KITTITAS COUNTY

MEMORANDUM

TO: All Staff
FROM: Public Works Plan Review Team
DATE: October 5th, 2023
SUBJECT: Public Works Comments: BL-23-00023 M&M Lowe Family LLC

- SET 5/8" REBAR W/ CAP
- FOUND PIN & CAP LS36815 UNLESS NOTED OTHERWISE
- x — FENCE

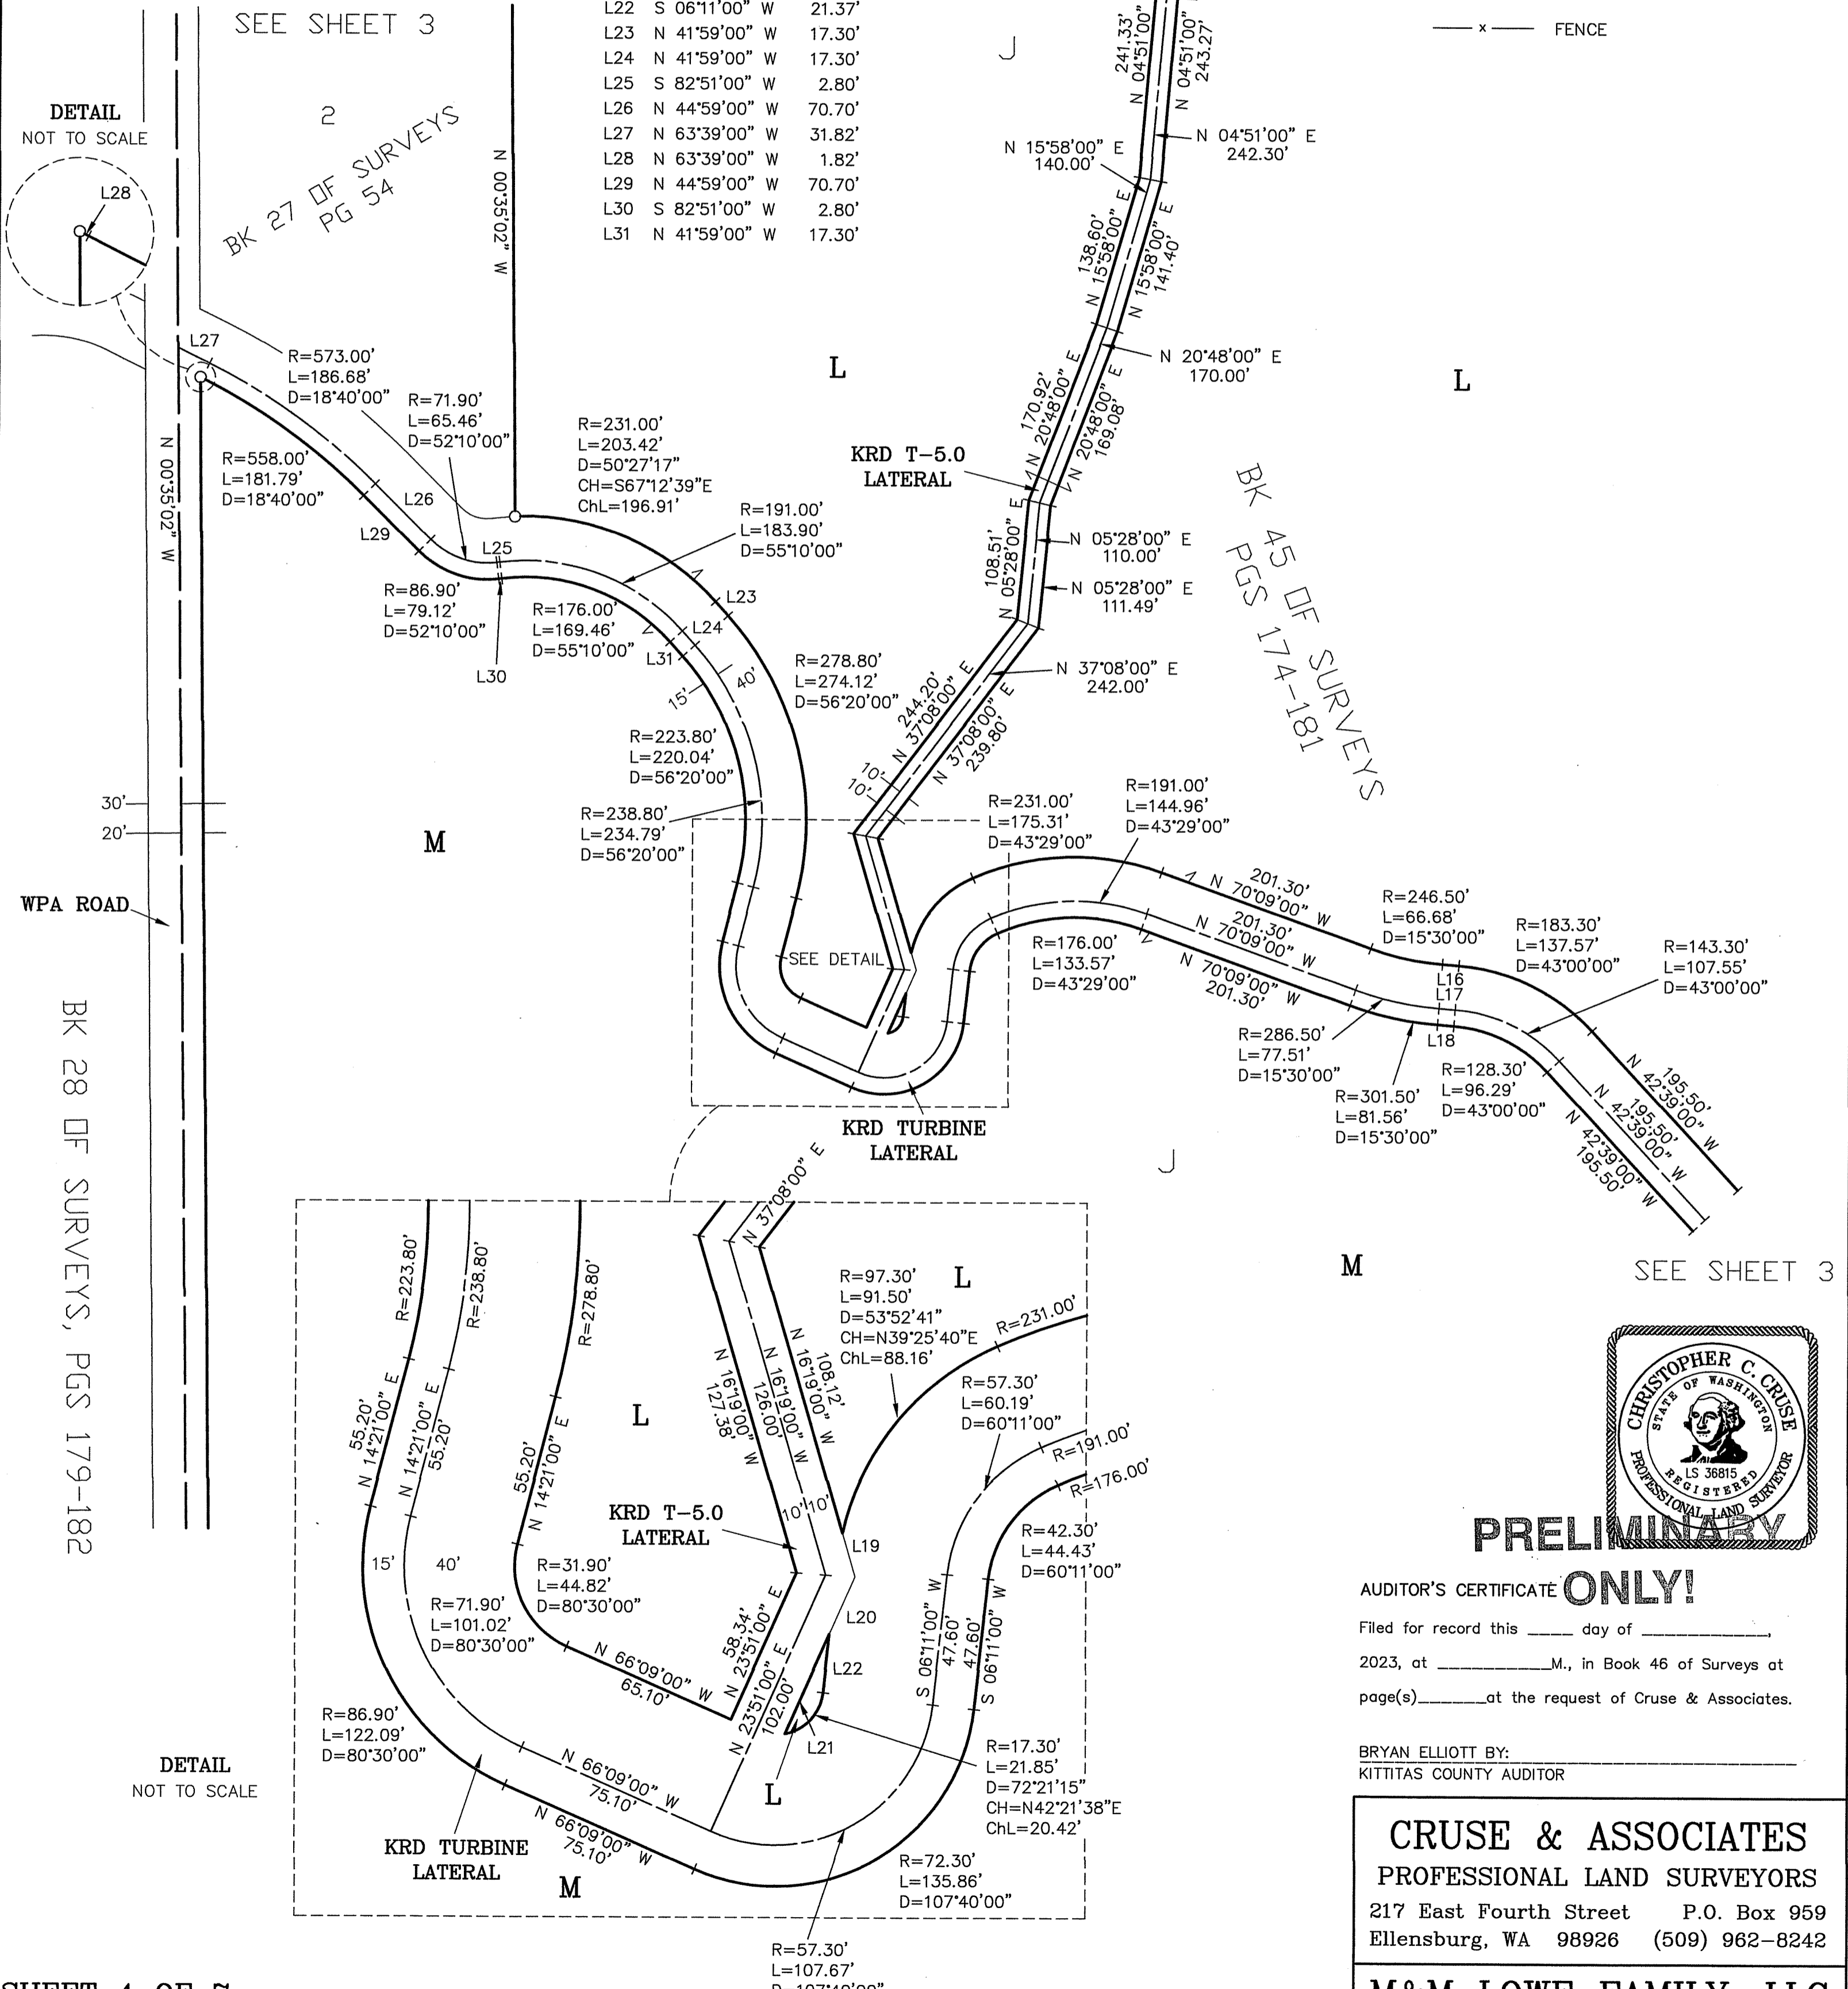
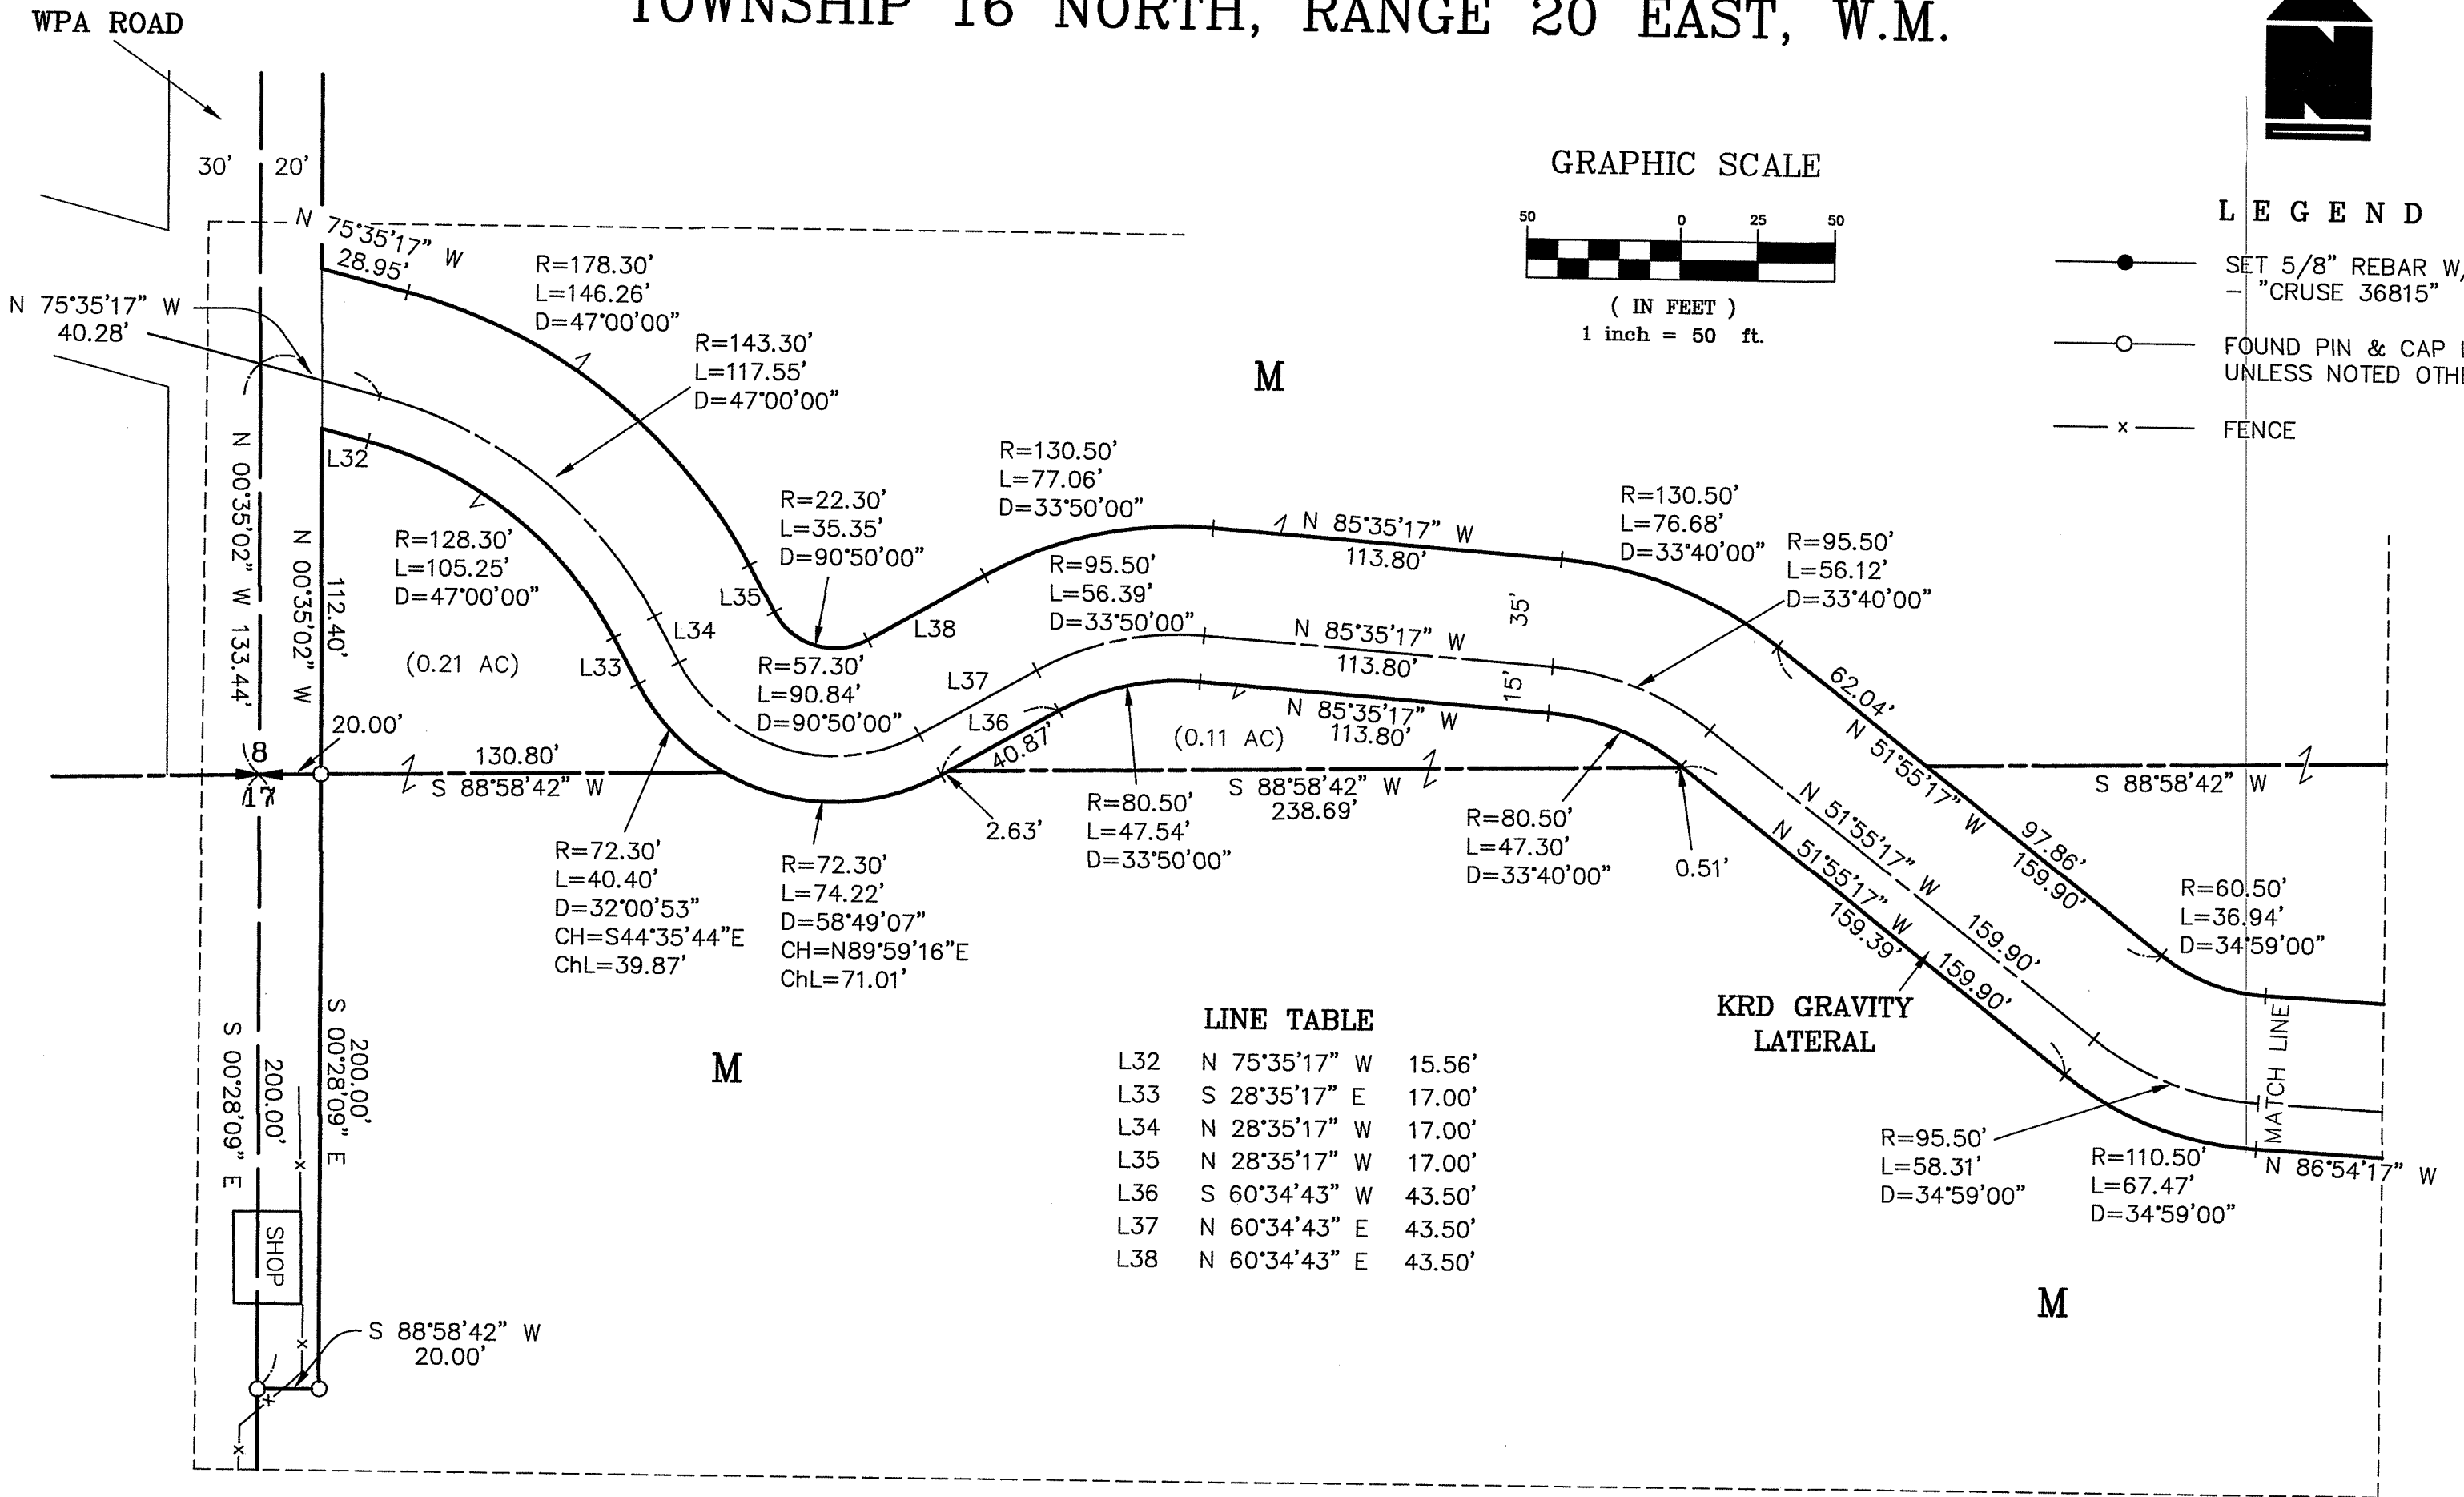
<p>SURVEY</p>	<p>As the application does not contain a survey map, survey reviewed is reserved until final submittal. (JT)</p> <p>UPDATE 11/21/2023</p> <ol style="list-style-type: none"> 1. Please include the R/W width, ownership and surfacing for all roadways. 2. Please show the total distance for the S line of SE1/4 of Section 8. 3. On Sheet 5, Please include the distance along the section line for the E' most portion of Parcel M, in Section 17 N of the lateral (780.56 per the closure rept). 4. Please remove the thin grey line that runs through the legend on Sheet 5. (this may be a result of printing or scanning) 5. (this may be a result of printing or scanning)
